Environment, Climate Change & Water

Bloomfield Coal Project (07_0087) Section 75W Modification Application

ATTACHMENT A**DECCW COMMENTS – BLOOMFIELD COAL PROJECT MODIFICATION - ENVIRONMENTAL ASSESSMENT (DA 07 0087MOD1)****1. GENERAL**

Figure 2: Flora and fauna survey locations

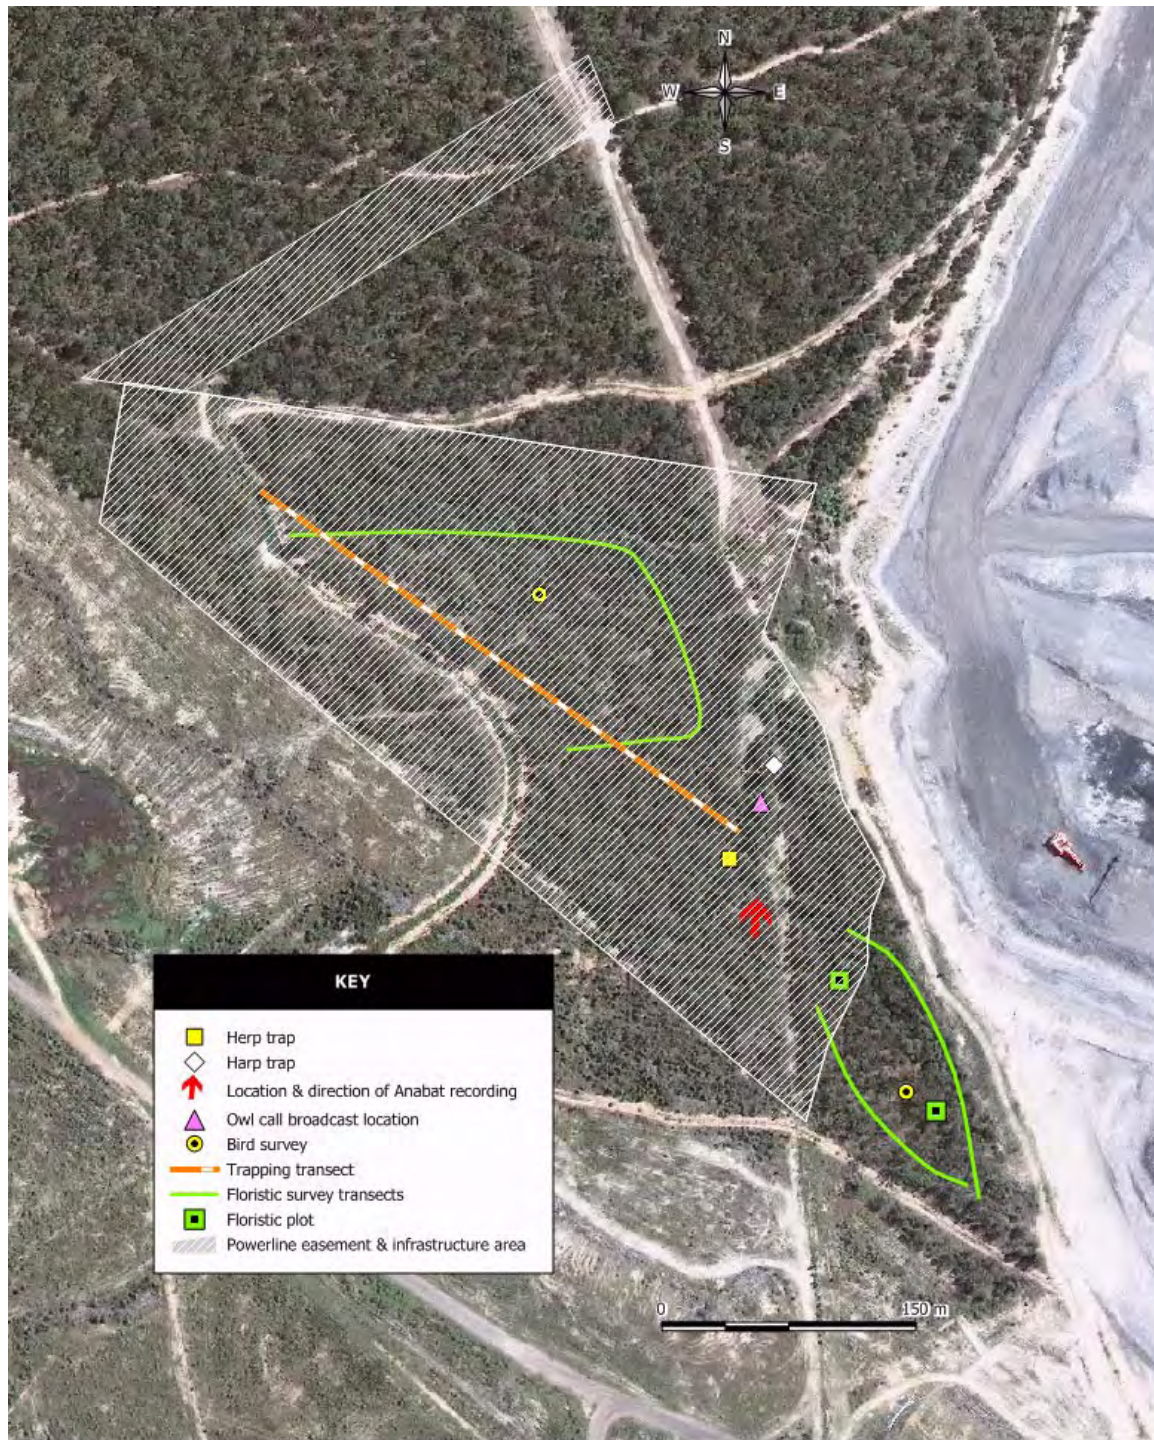
Based on Figure 2 of the Biodiversity Assessment, limited floristic plots and random meanders (i.e. transects) were conducted, in some instances outside of the development footprint as opposed to within the development footprint. DECCW believes flora survey effort is insufficient.

One floristic plot within the proposed modification Area D is not sufficient to assess vegetation across all five areas proposed in the modification. At a bare minimum, four floristic should have been conducted in Area D given the two vegetation types identified were identified in this area (based on DEC 2004). Similarly, no details on species, dates, effort and location of targeted surveys are provided. DECCW would have expected specific targeted flora searches to have been conducted at time when a species is readily detectable (i.e. for taxa require flowers and/or fruits during their appropriate flowering / fruiting times).
